Application No: A/25/21/A
Site Address: Land South of Water Lane Angmering
Description of works: Erection of 5 No. non-illuminated Banner flags and 10 No. non-illuminated Totem signs.

Thank you for your internet representation made on 8th March 2021 which has been recorded as an objection with the comments as follows:

Project
**Land at Water Lane,
Angmering, West Sussex.**
Drawing Title
Sales Area Layout

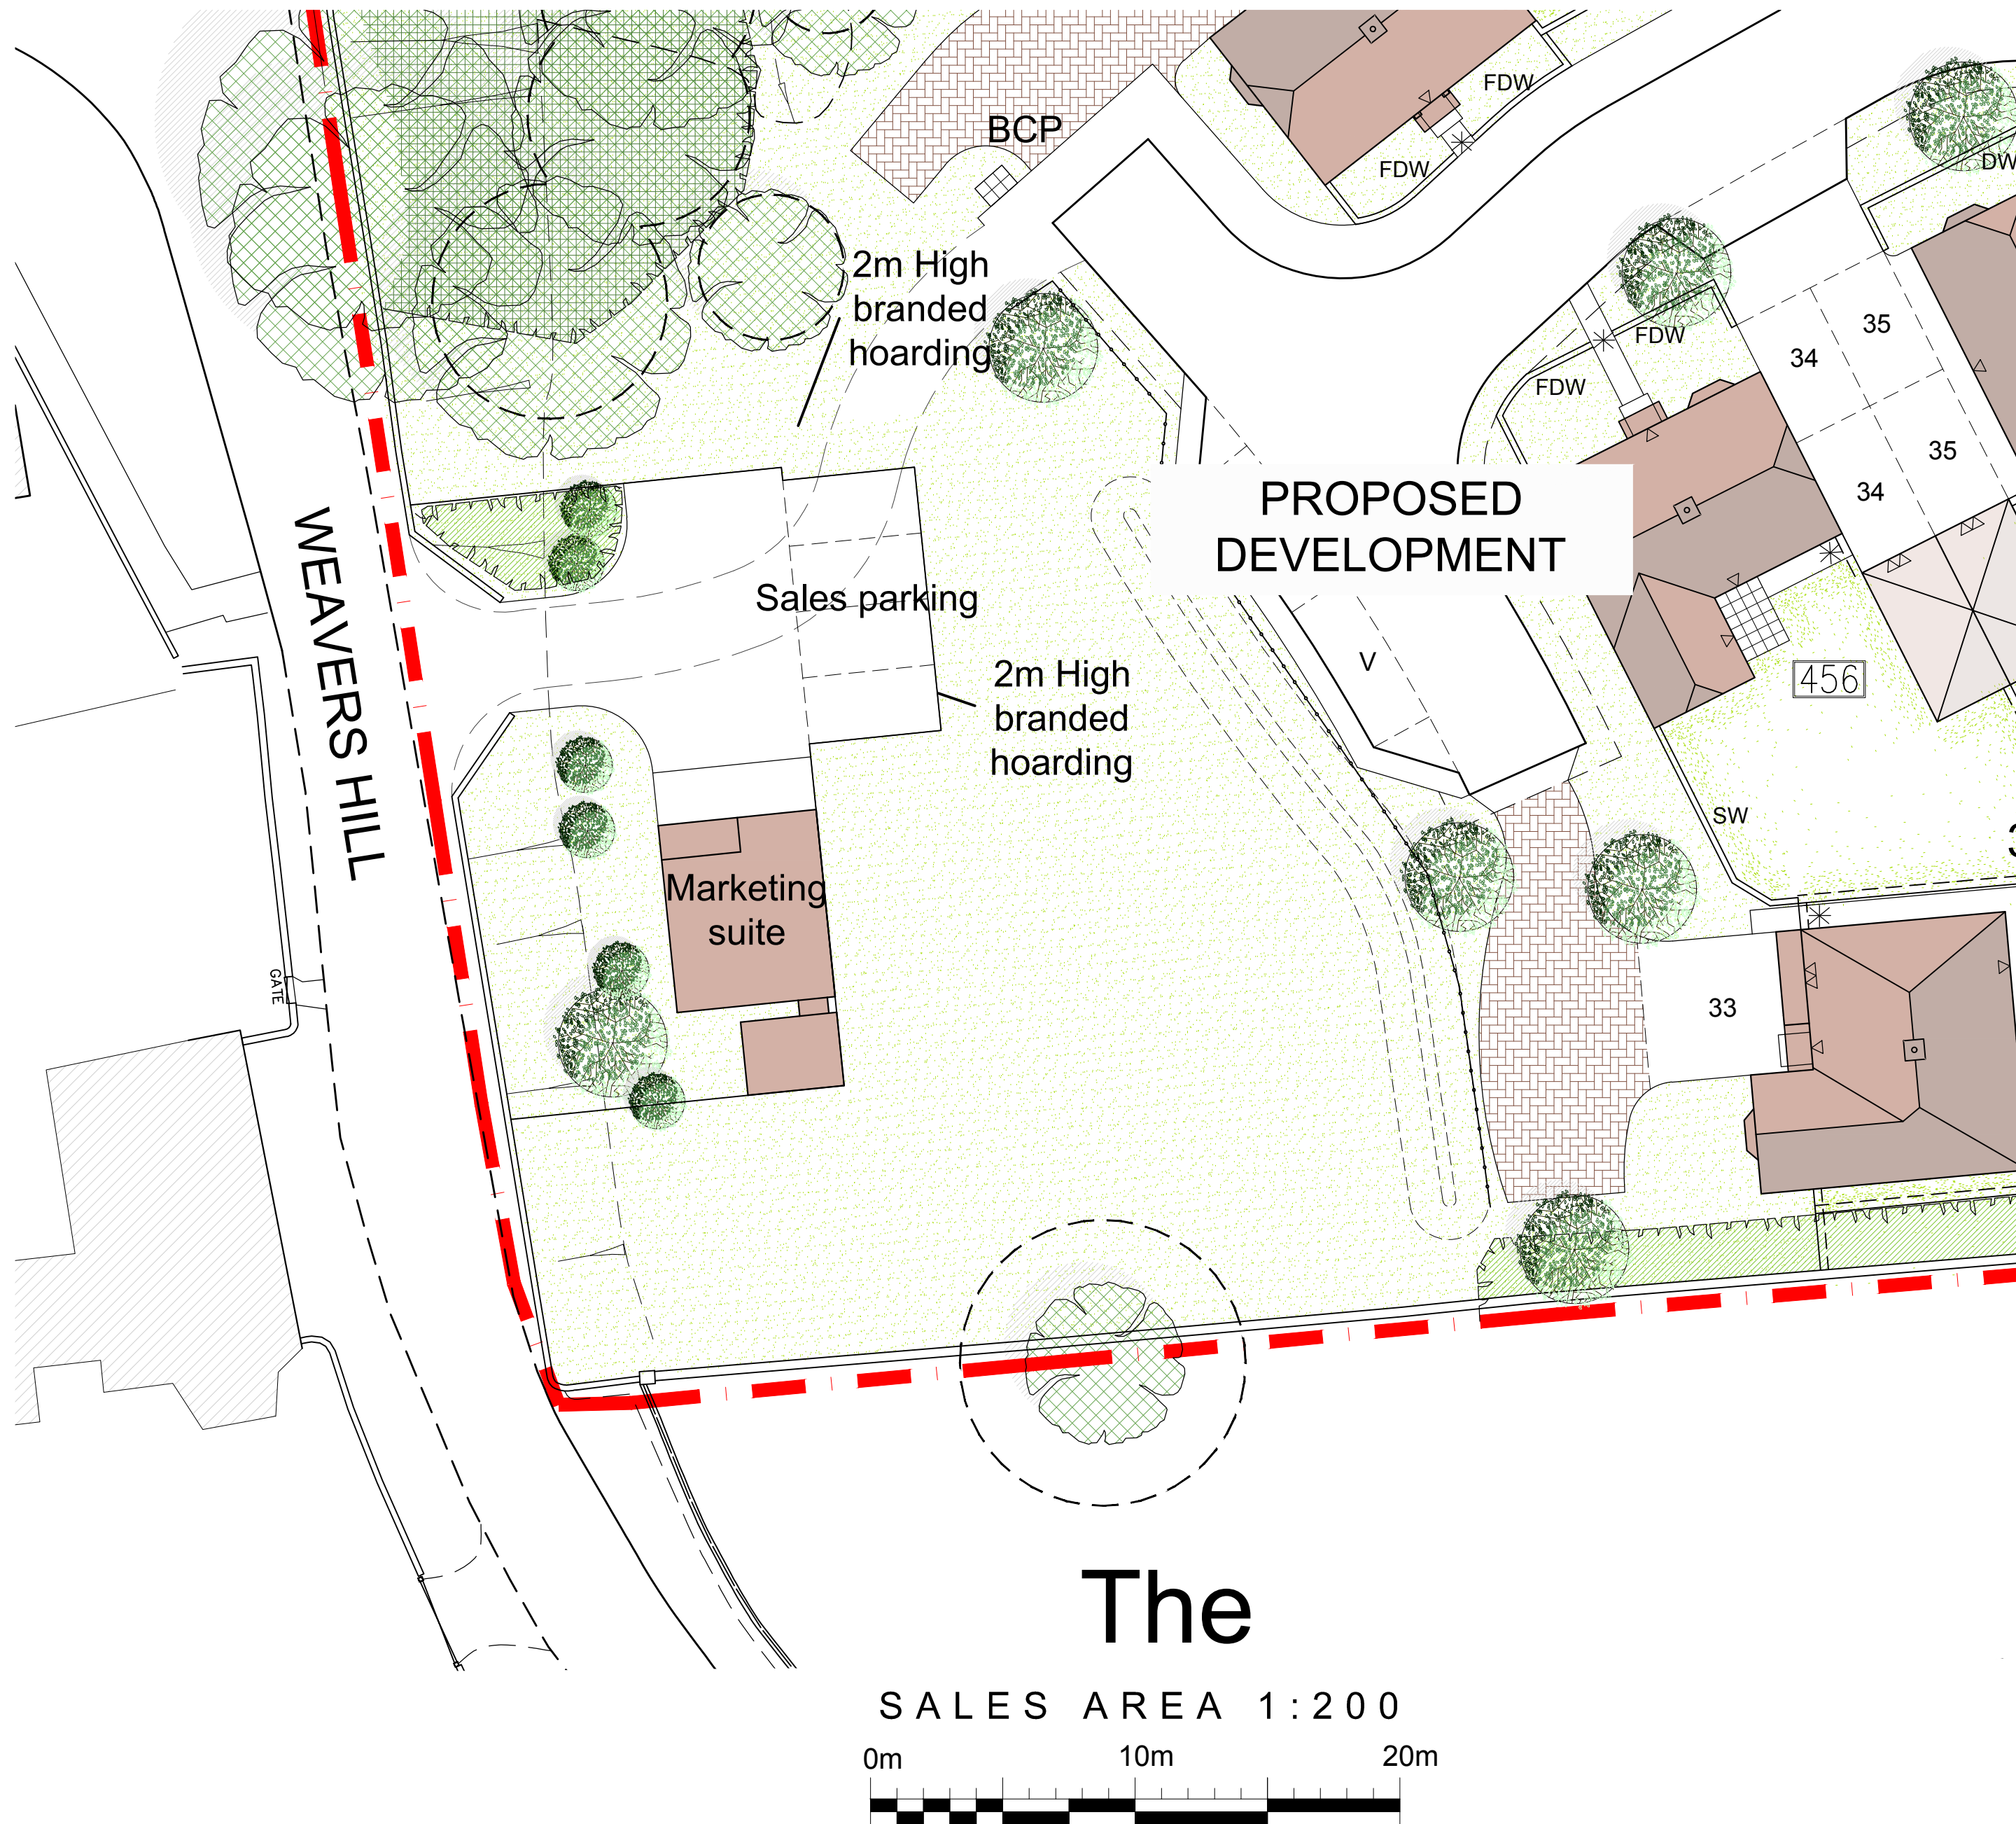
With reference to drawings within the plan, the proposal will require cutting through the long-standing flint wall at the top (south) end of Weavers Hill to facilitate access / egress with the development's sales suite. Why is this needed when there is already an established access point to the site at the southbound bus stop location (opposite Cumberland Drive)?

The wall cut point will be at the narrowest part of an already narrow lane and at a partially blind (both directions) road position. This will result in sporadic vehicle movement in a tight road thus presenting an increased accident risk (both actual and near miss based) in an area already too narrow in any case. The road section is also shared by pedestrians as there is limited footpath in that location. There would also be disruption to the no. 9 bus route at that narrow point.

There would, I am certain, be resistance by the development contractor to re-instate the wall on completion to grab additional access / egress for the overall development. I understand the overall approved "Land South of Water Lane" project includes for pedestrian use only at the existing access location mentioned above no doubt because it is wholly unsuitable for regular ongoing vehicle use.

I strongly object to the proposal due to an apparent lack of suitable study by the applicant as the solution is plainly impractical due to increased road and pedestrian accident / incident potential and adverse disruption to an already difficult traffic flow.
